A30 Chiverton to Carland Cross TR010026

8.6 COMMENTS ON WRITTEN REPRESENTATIONS

March 2019

Drawing file: TR010026 / TR010026-000194-6.3 ENVIRONMENTAL STATEMENT FIGURE 2.1 GENERAL ARRANGEMENT PLANS SHEET 4 OF 8.pdf

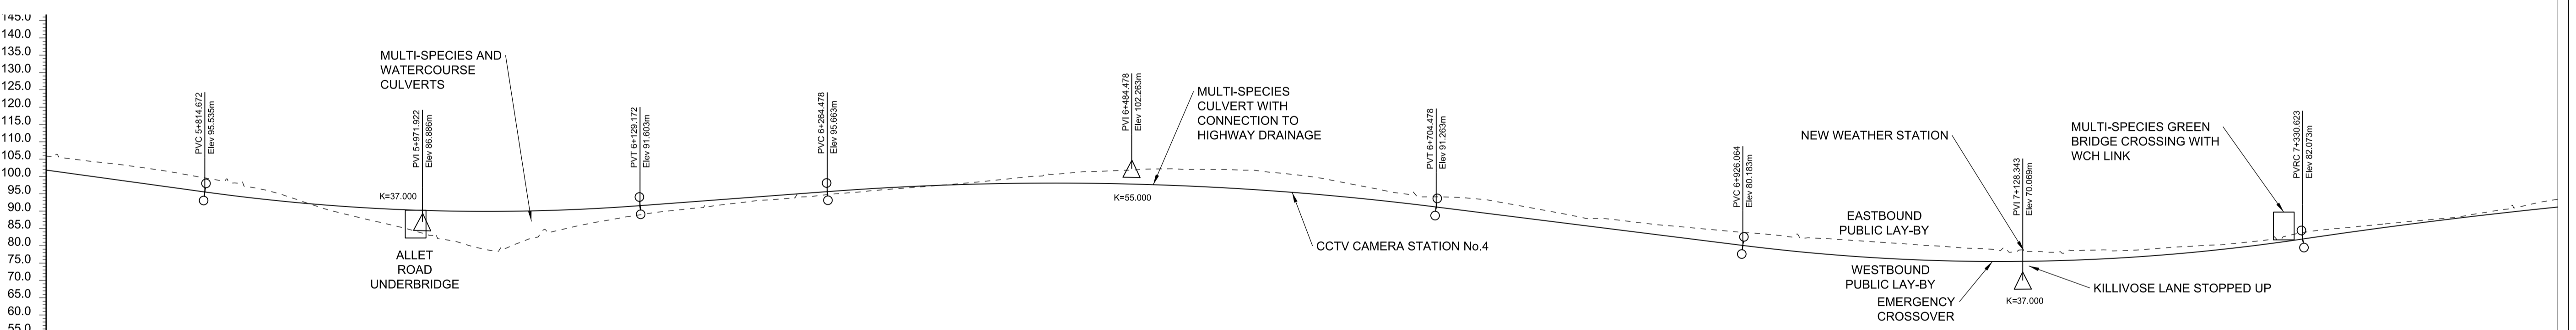
| Reference | Interested Party | Written Representation | Highways England Response |
|-----------|------------------|--|--|
| | | <ul style="list-style-type: none"> • VA in this section has been greatly debated. We remain very concerned about any flexibility that may allow the vertical alignment to be raised during the construction works as this significantly increase the adverse impacts in this very sensitive area. | <p>A stated in paragraph 4.3.7 of Chapter 4 Approach to Environmental Impact Assessment of the Environmental Statement (Document Reference 6.2) [APP-057] the vertical limit of deviation is restricted in the area of Nancarrow Farm and Marazanvose, meaning that the flexibility to increase the level of the road is not available in this area.</p> <p>This is secured in Article 8 of the draft DCO (Document Reference 3.1(B)) [AS-031] and shown on Sheet 4 of the Works Plans (Document Reference 2.4(B)).</p> |
